DR STEPHEN DEBUS OSPREY PLATFORM LETTER

**Re: erection of Osprey platform and nest at  
Lot 3 DP 583296 Edinburgh Drive, Taree**

**PLAN OF PROPOSED
OSPREY NEST/PLATFORM
LOCATION**

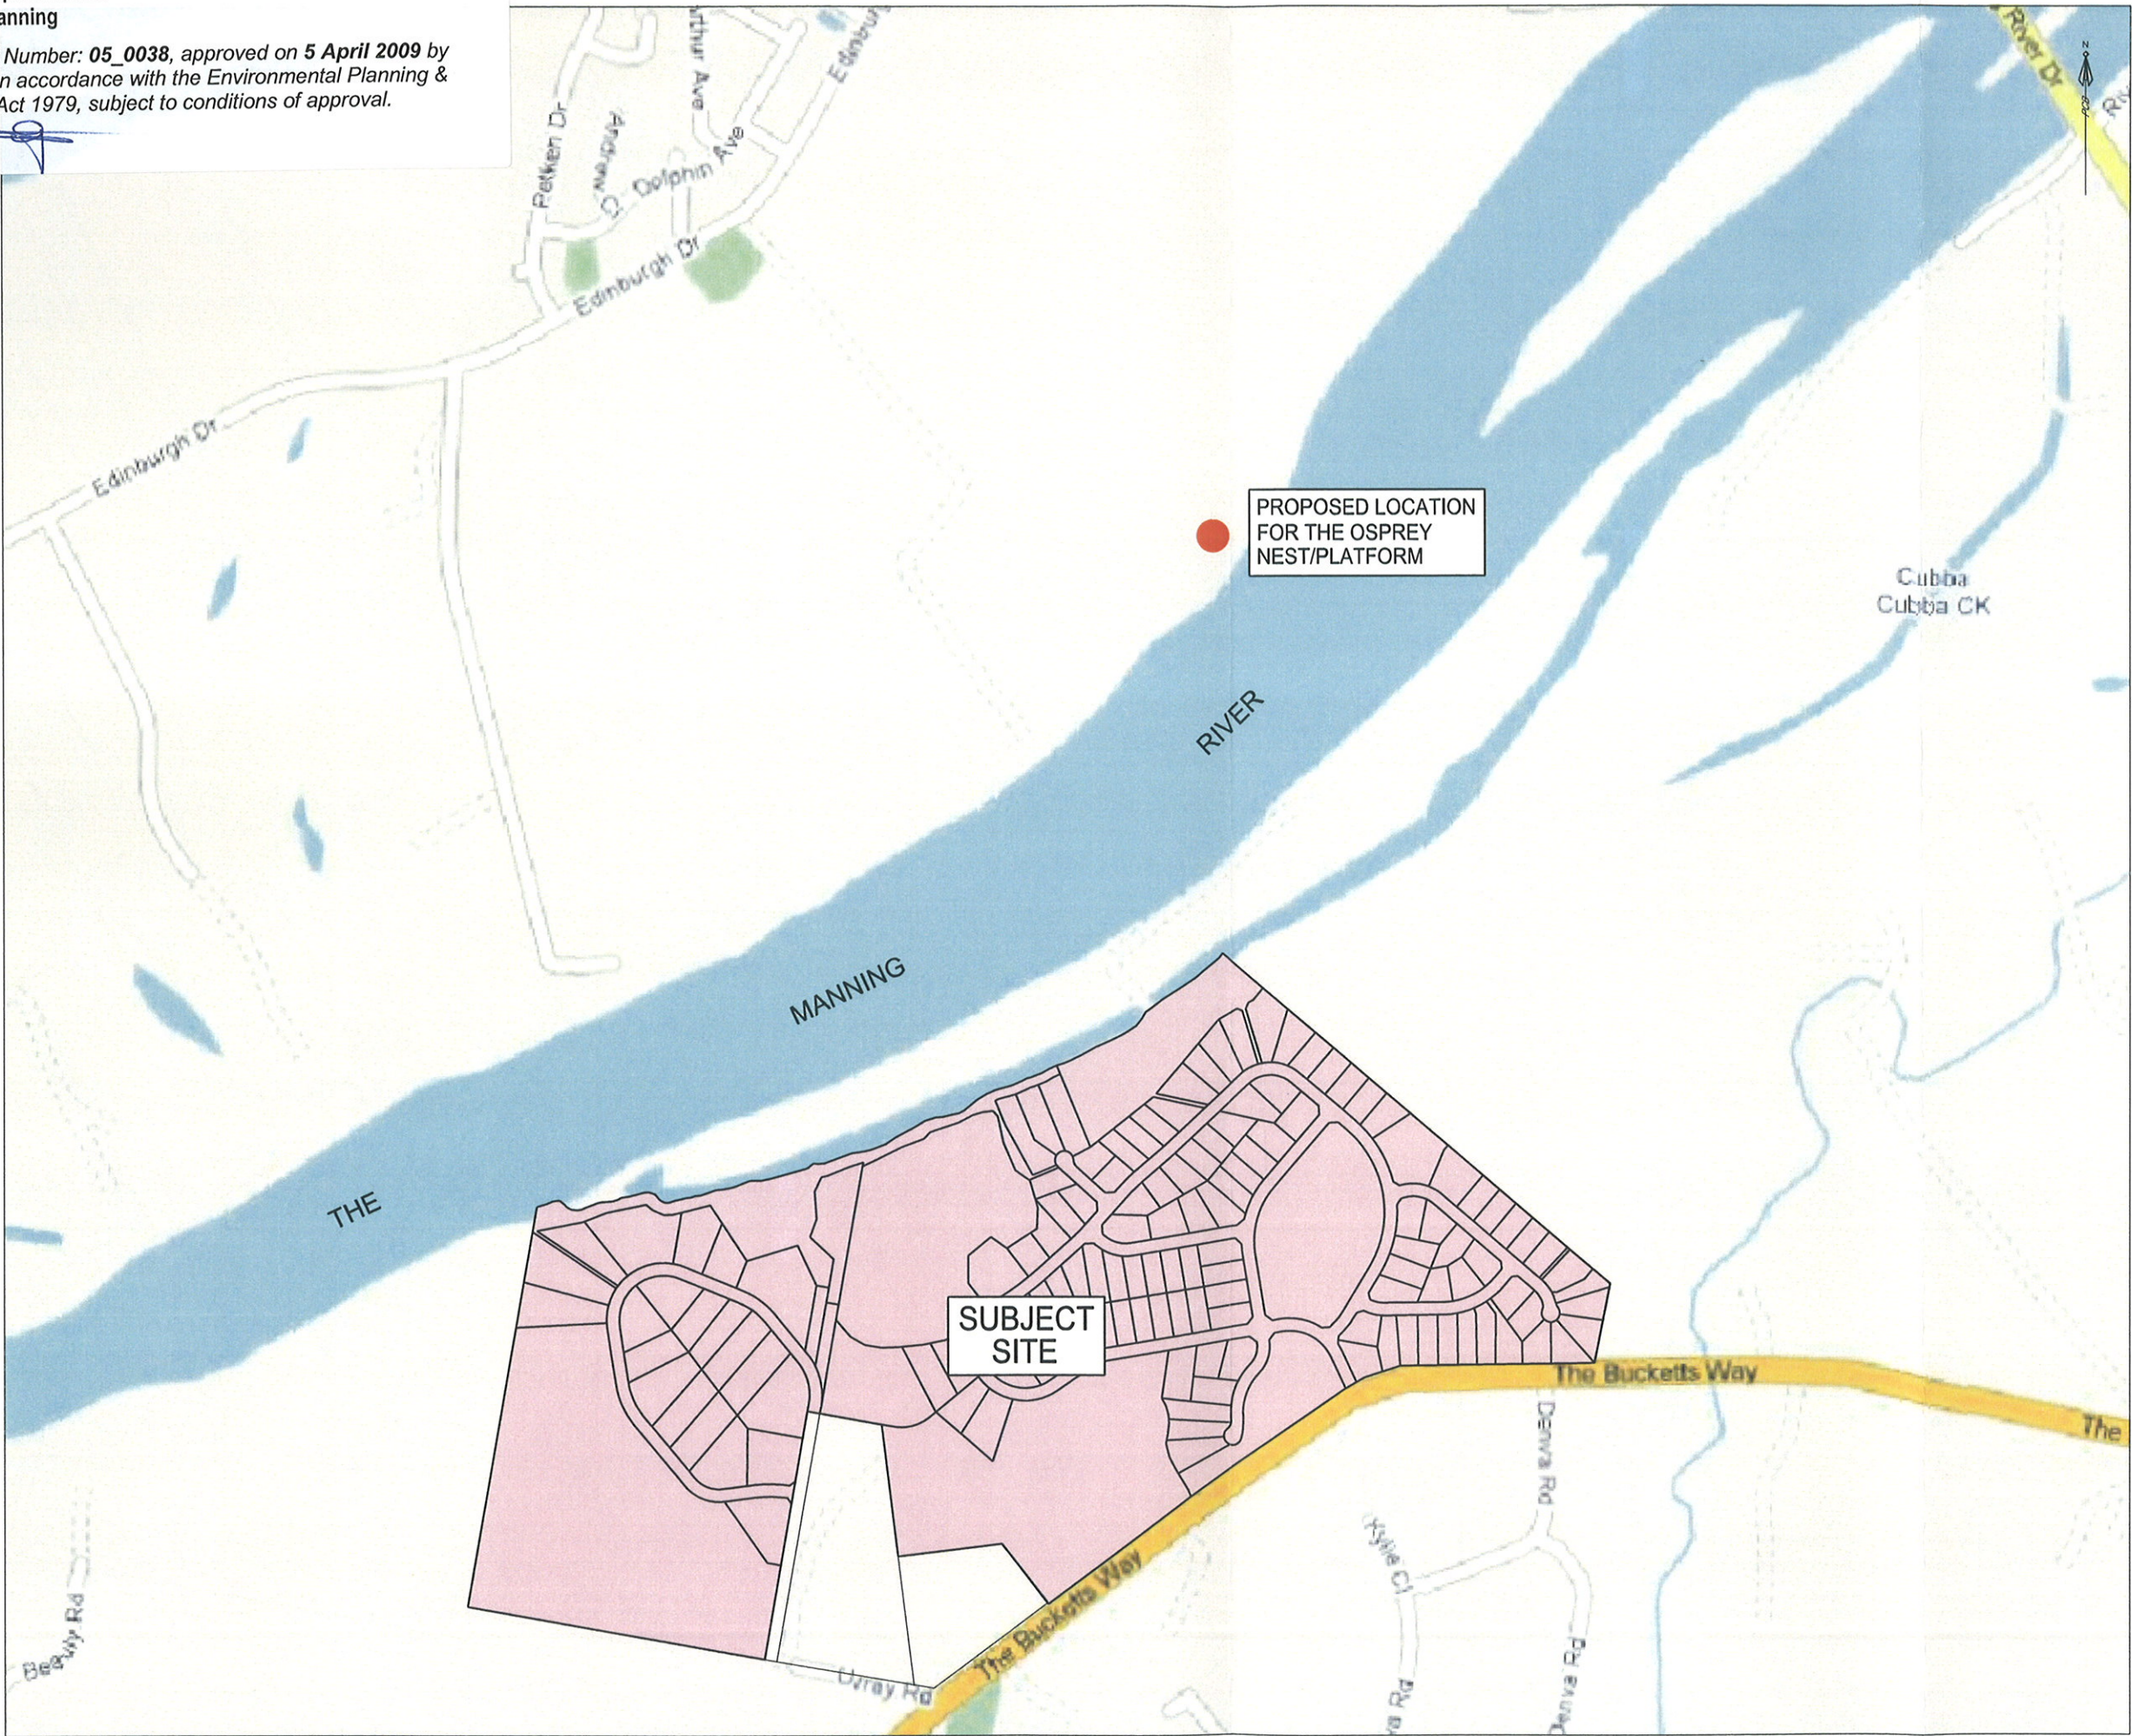
It is my opinion that the proposal to place the platform at the location indicated in the attached letter and map is an acceptable solution. I would suggest also that several perching poles be erected near (within 50 m of) the platform if this is feasible and there are no large live or dead trees in the vicinity, to provide fledgling Ospreys with safe perches.
